**To:** Beth Boepple, Chair, and Members of the Portland Planning Board  
**From:** Nell Donaldson, Planner  
**Date:** November 5, 2015  
**Re:** AC Hotel, 158 Fore Street  
**Project #:** 2015-169 **CBL:** 19-B-2  
**Meeting Date:** November 10, 2015

Portland Norwich Group has requested a preliminary Level III site plan and subdivision review for the development of a 6-story 120,760 SF building at 158 Fore Street in the Eastern Waterfront. The project includes a 150 room hotel, 16 residential condominium units, and 4,000 SF of ground floor retail, some of which may be fit up as restaurant space. The plans show enhancements to the Fore Street, Hancock Street, and Thames Street streetscapes, new vehicular and pedestrian circulation interior to the site, landscaping, and stormwater treatment.

6 CONCRETE ENCASED DUCT

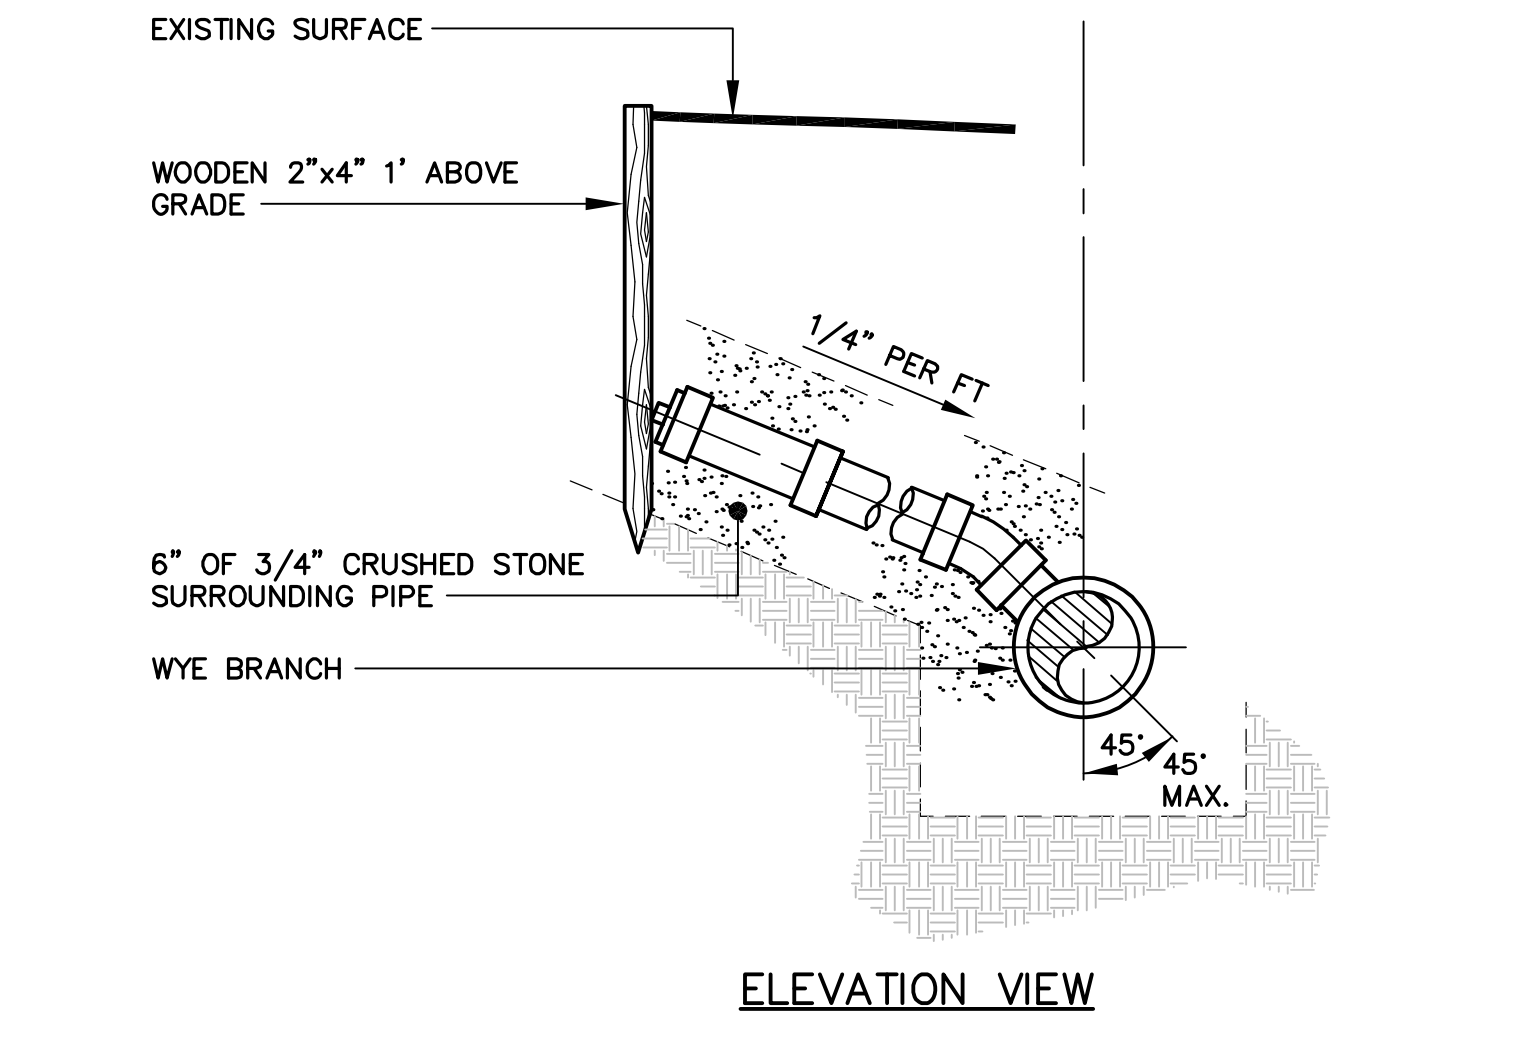
*Underground electric power (and underground communication) conduits in the street right of way should be incorporated into concrete encased duct banks. The details on sheet C2.0 should be revised accordingly.*

6 R-TANK^{SD} - HS-20 LOADS
NOT TO SCALE

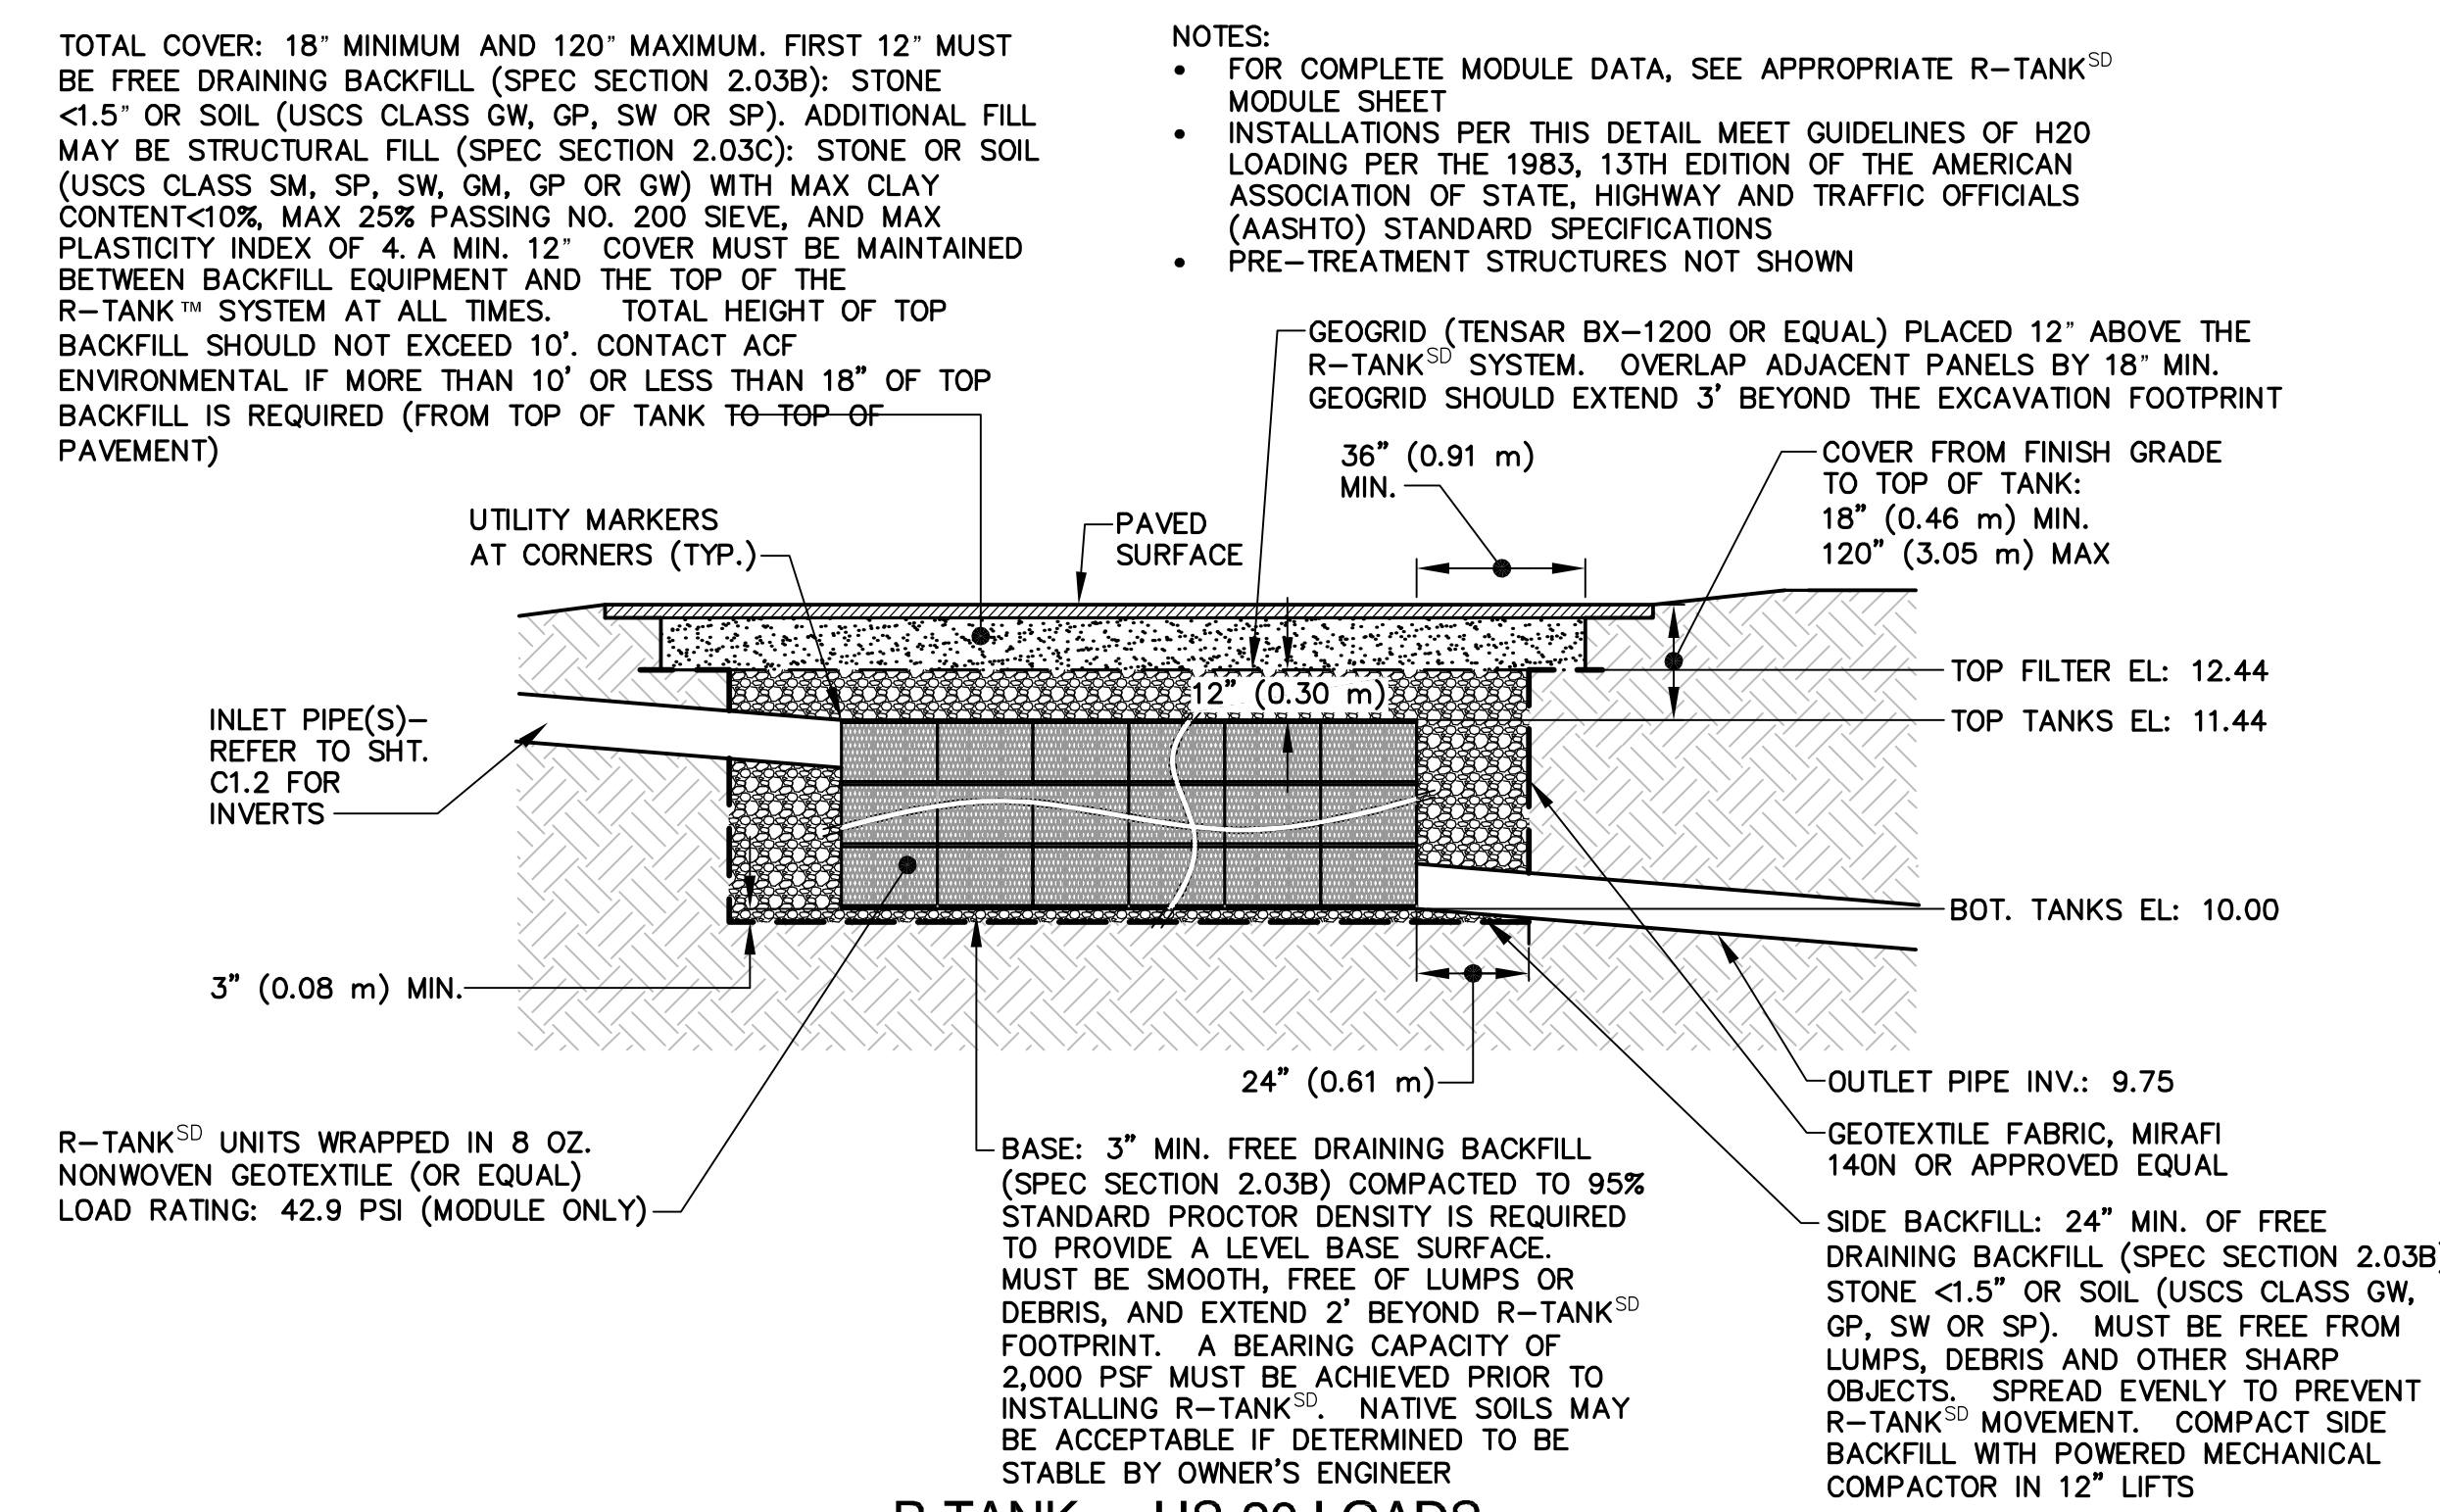
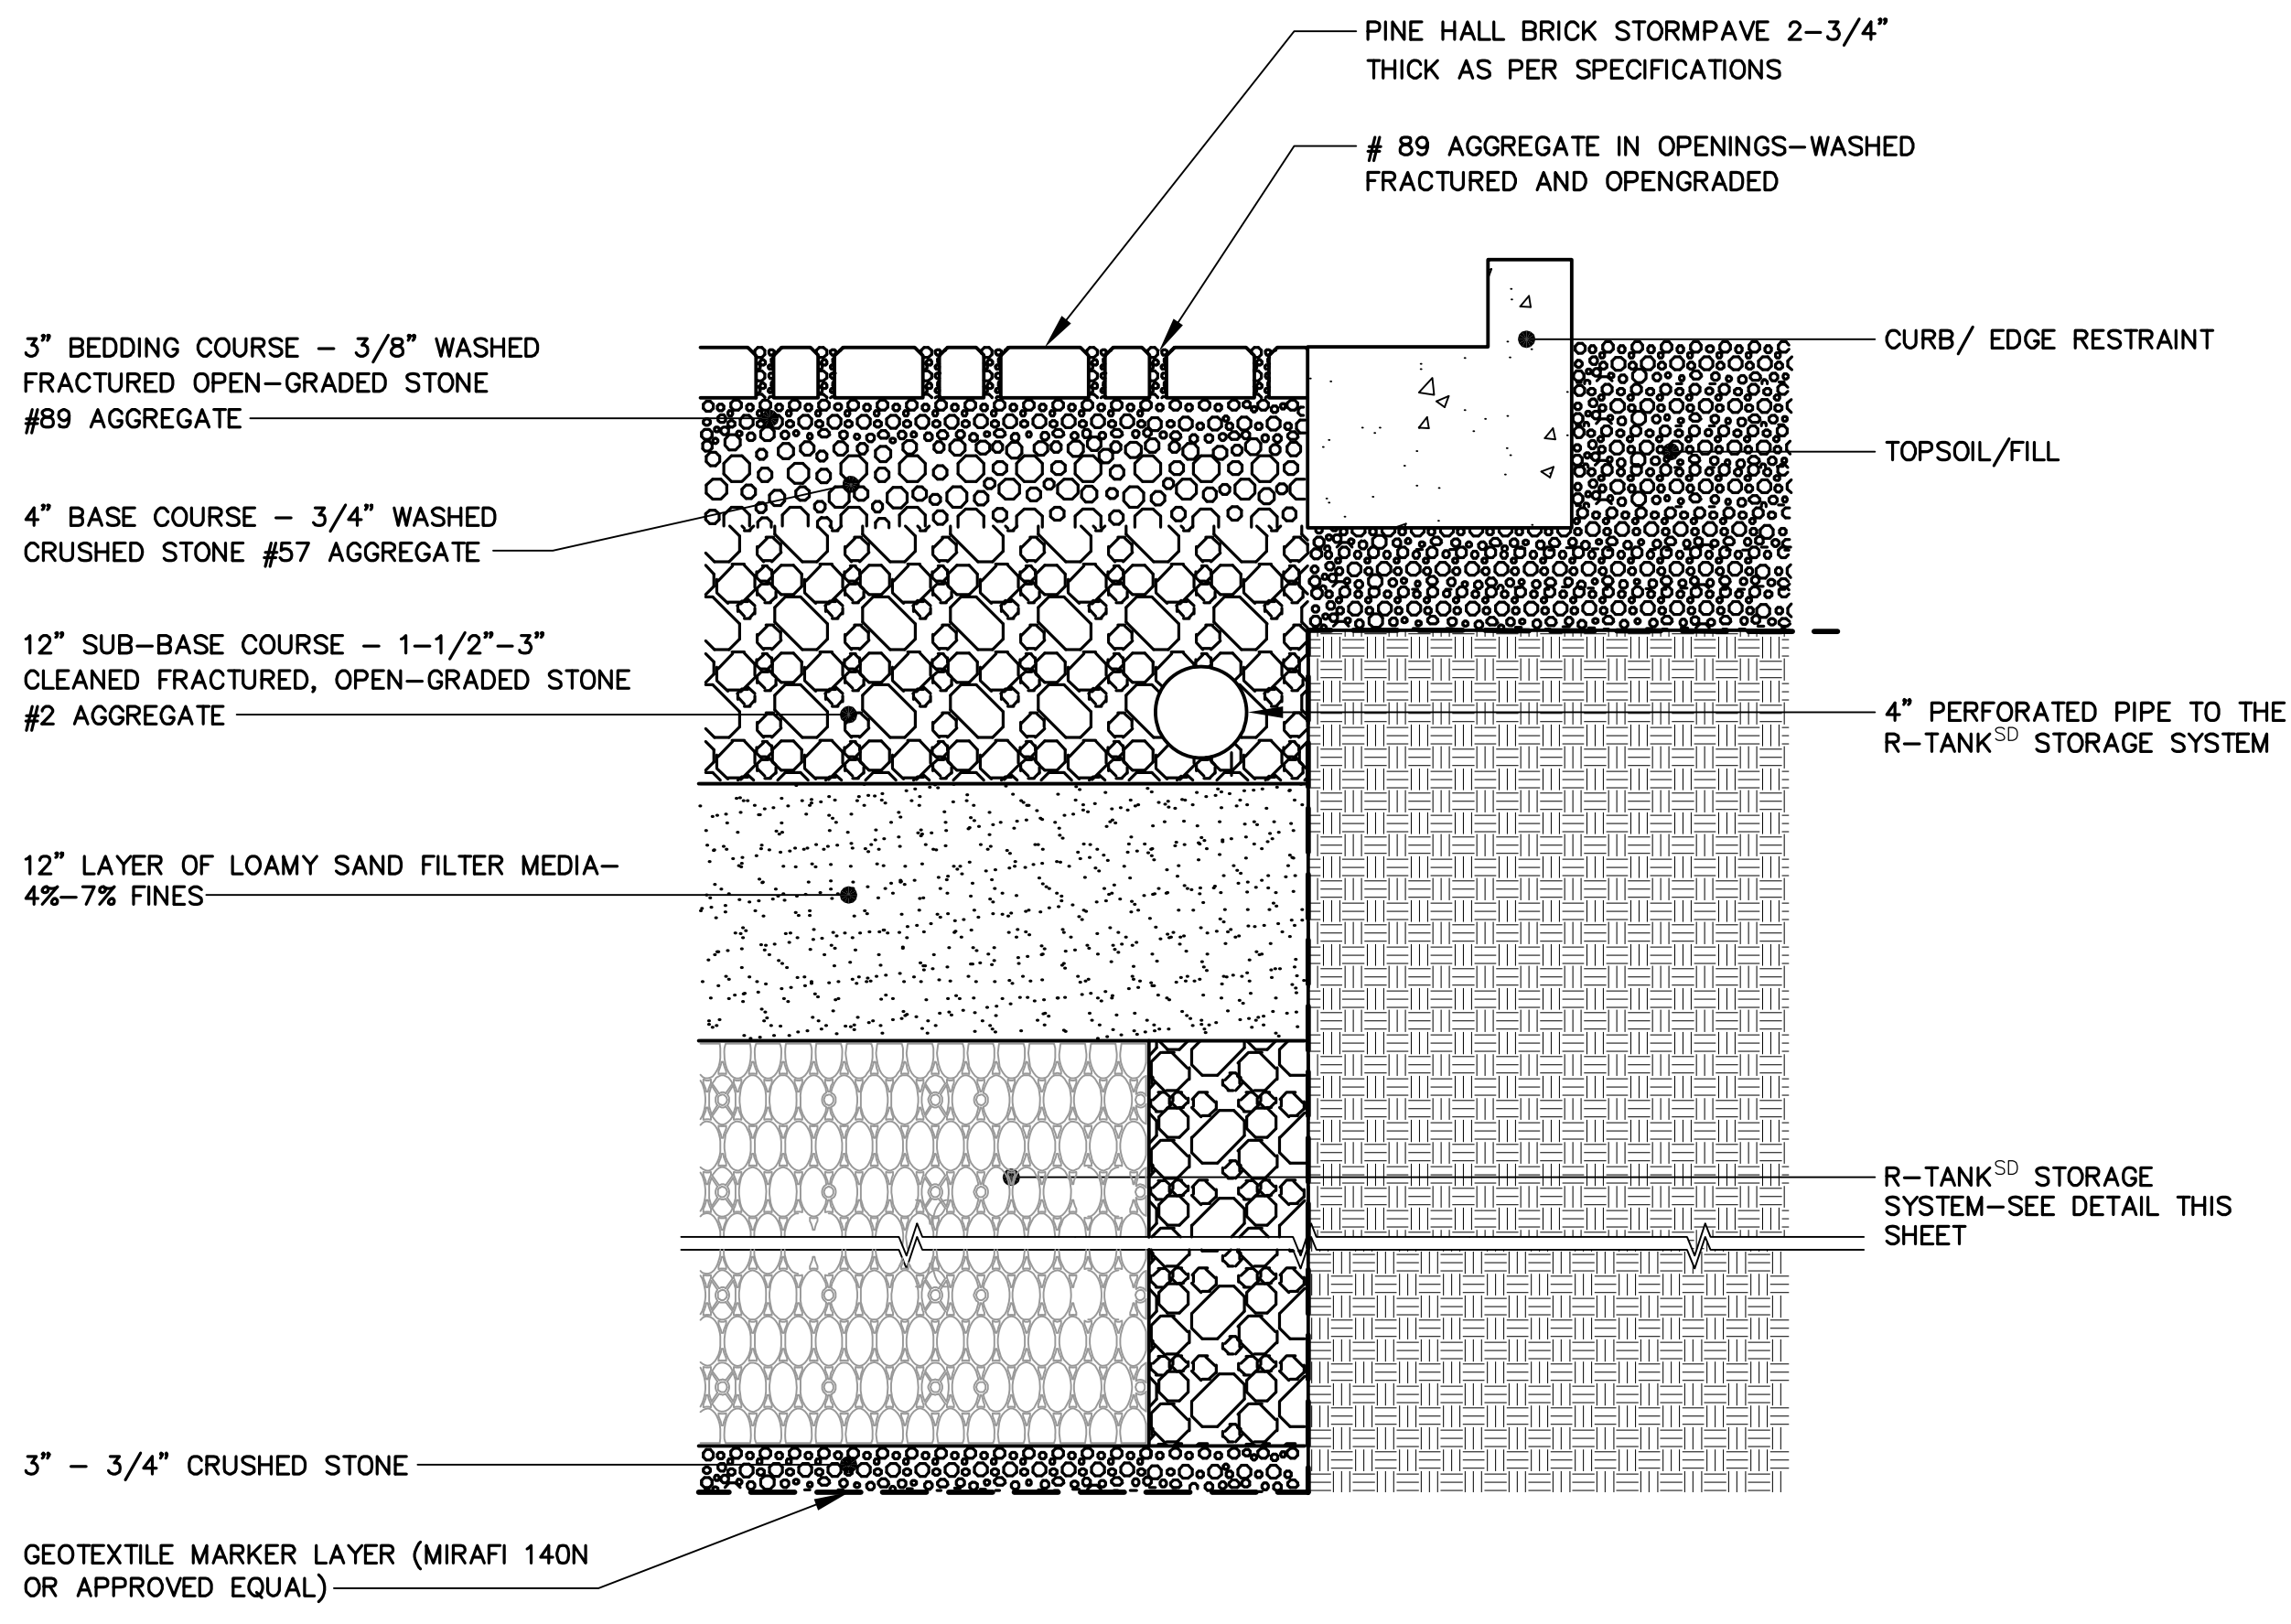
*The Applicant should show details for the proposed R-Tank System.*
